WEST SUSSEX COUNTY COUNCIL CONSULTATION

TO:	Arun District Council FAO: Obafemi Okusipe
FROM:	WSCC - Highways Authority
DATE:	16 February 2022
LOCATION:	Dutch Bicycle Company 46A & 46B Pier Road Littlehampton BN17 5LW
SUBJECT:	LU/33/22/DOC Approval of details reserved by condition imposed under LU/182/18/PL relating to conditions 8-details showing set up during construction, 11-surface water drainage & 12-existing and resulting ground levels & slab levels of buildings.
DATE OF SITE VISIT:	n/a
RECOMMENDATION:	More Information
S106 CONTRIBUTION TOTAL:	n/a

This application seeks discharge of conditions 8, 11 and 12 of LU/182/18/PL. Conditions 11 and 12 do not relate to highways matters and as such no comments will be provided for these.

Existing site and roof plan Scale 1:200 @A3

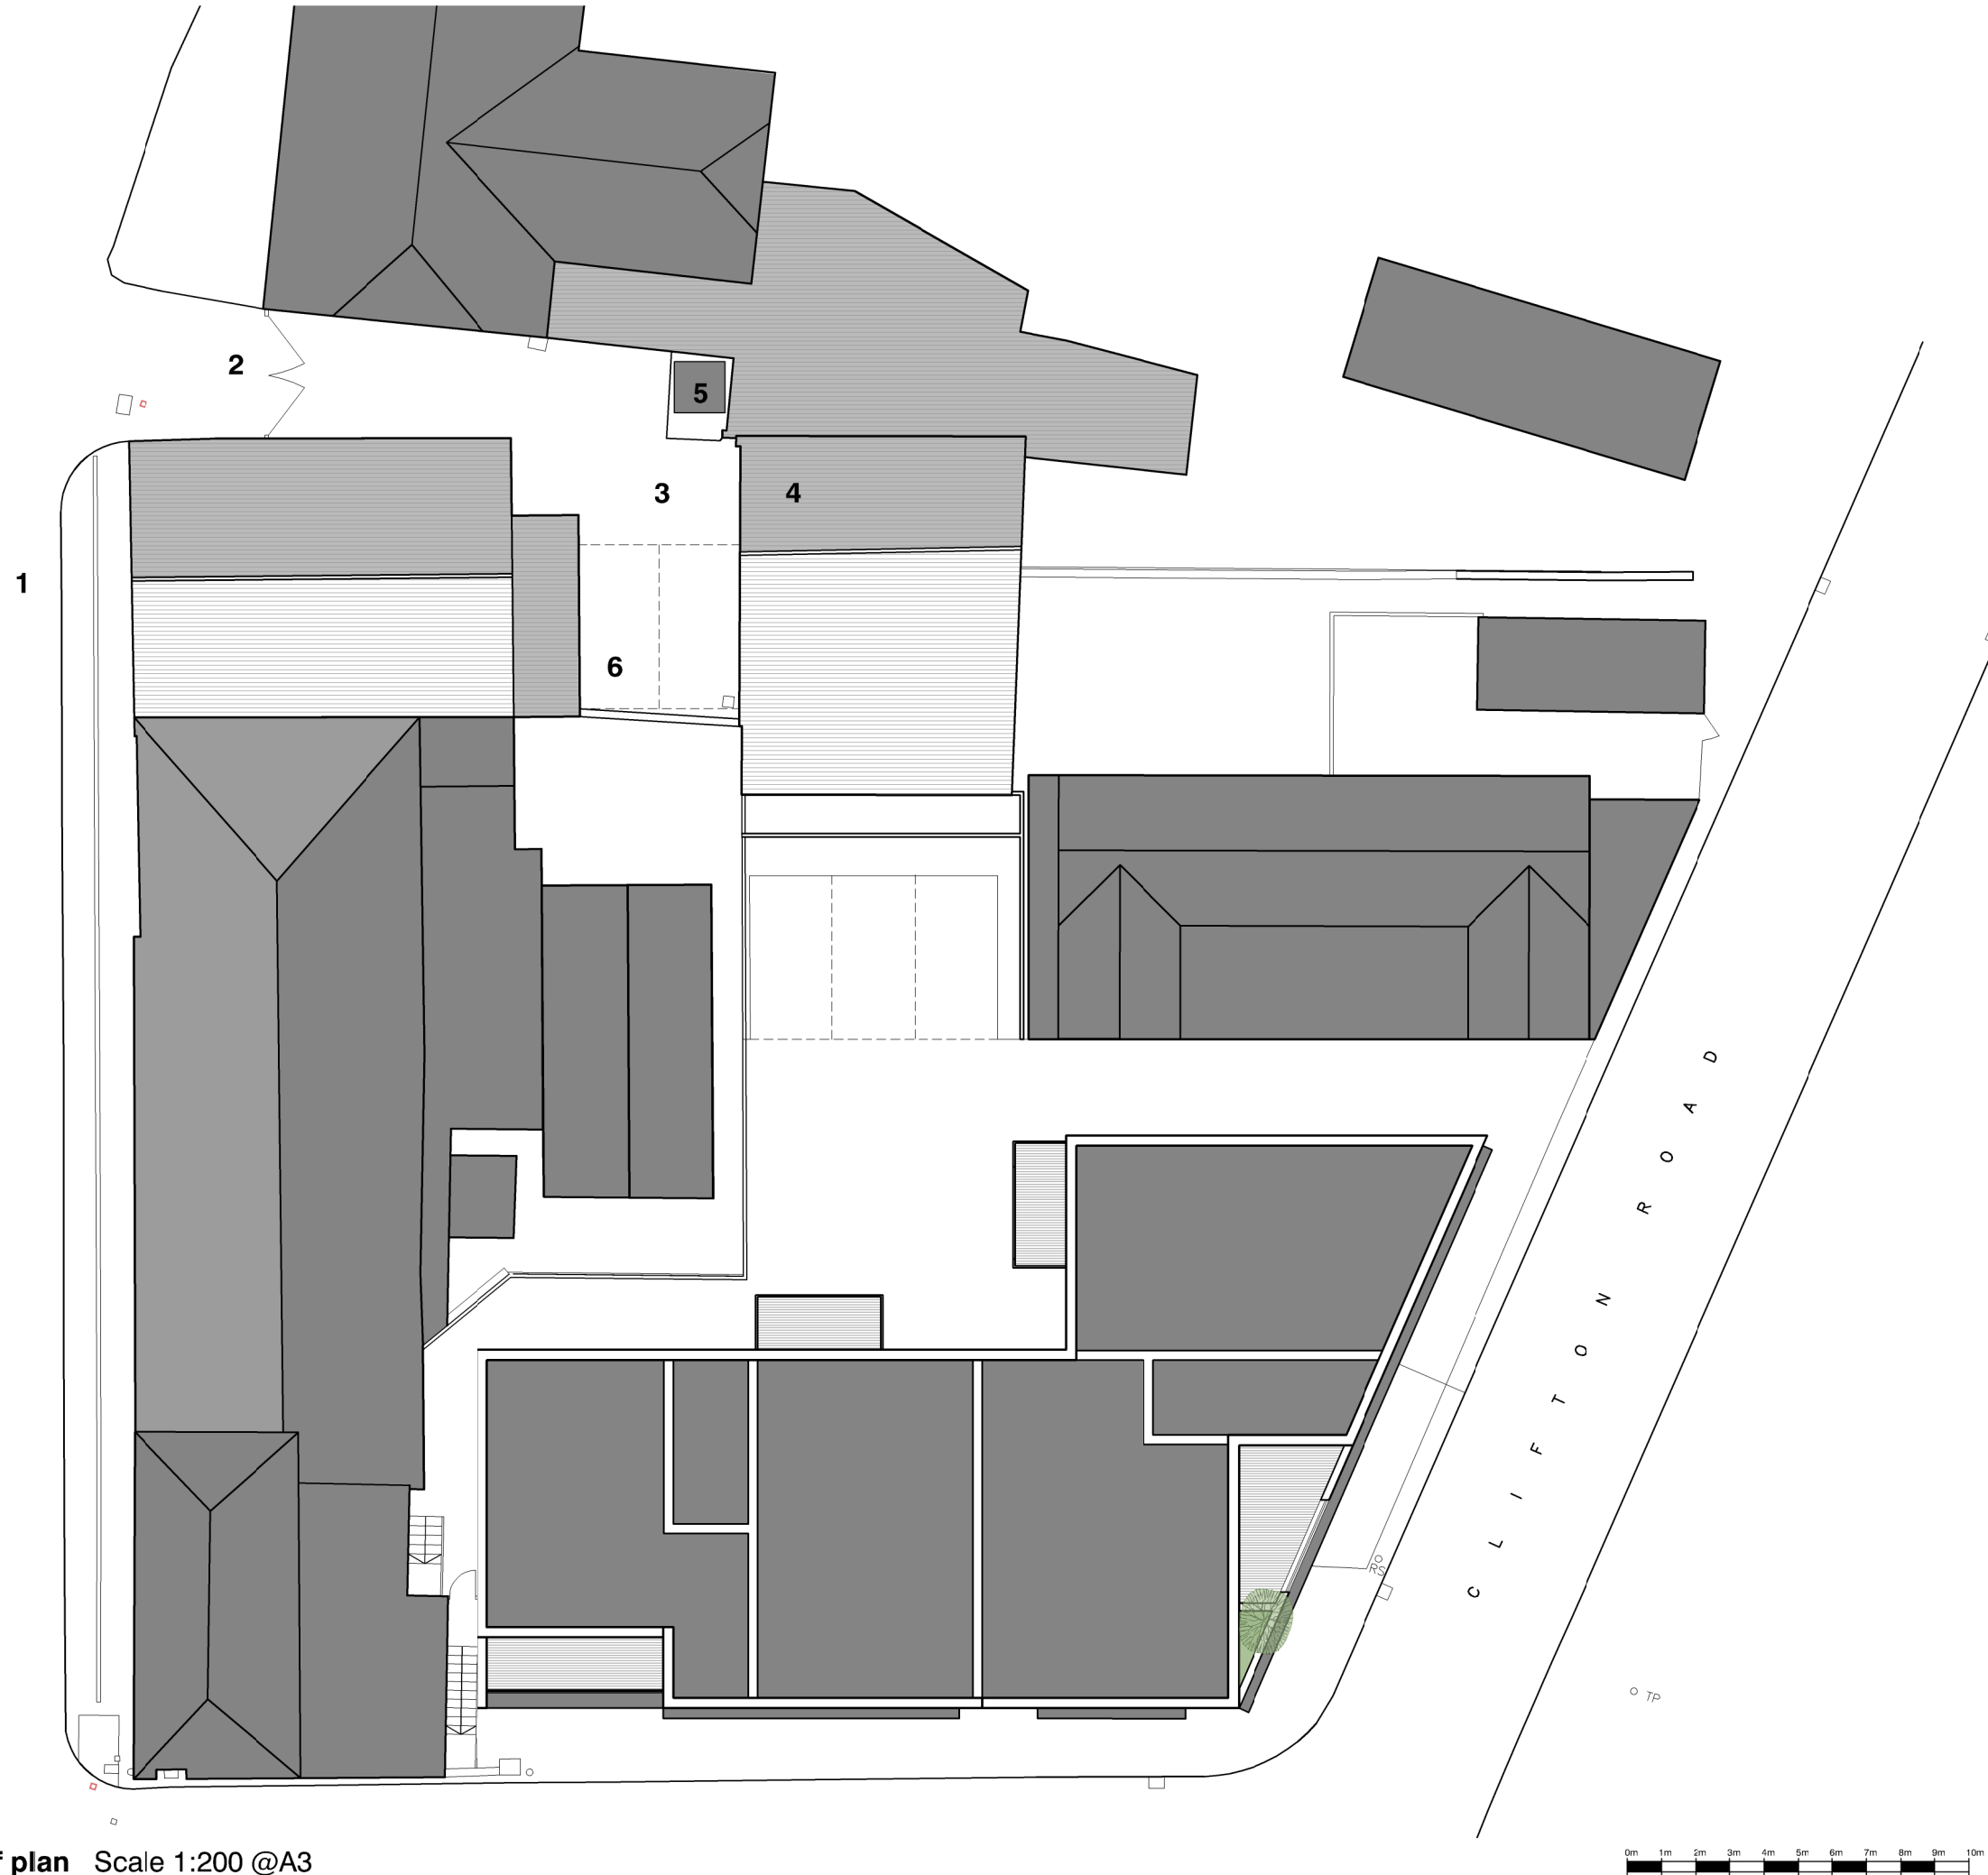
The proposed site set up plan demonstrates that temporary parking of contractors vehicles will be within the rear courtyard area. All materials and plant will be stored within the temporary contractors building to the rear of the site, which will also provide welfare facilities. Loading/unloading will take place on-street and materials taken immediately to the rear of the site, no materials for loading/unloading will be stored on the public highway. In principle the LHA is satisfied with this arrangement, but would request that a banksman be on site at all times to assist with safe traffic and pedestrian movements during loading/unloading of vehicles.

As above, the LHA is satisfied in principle, but requests confirmation from the applicant that a banksman will be provided.
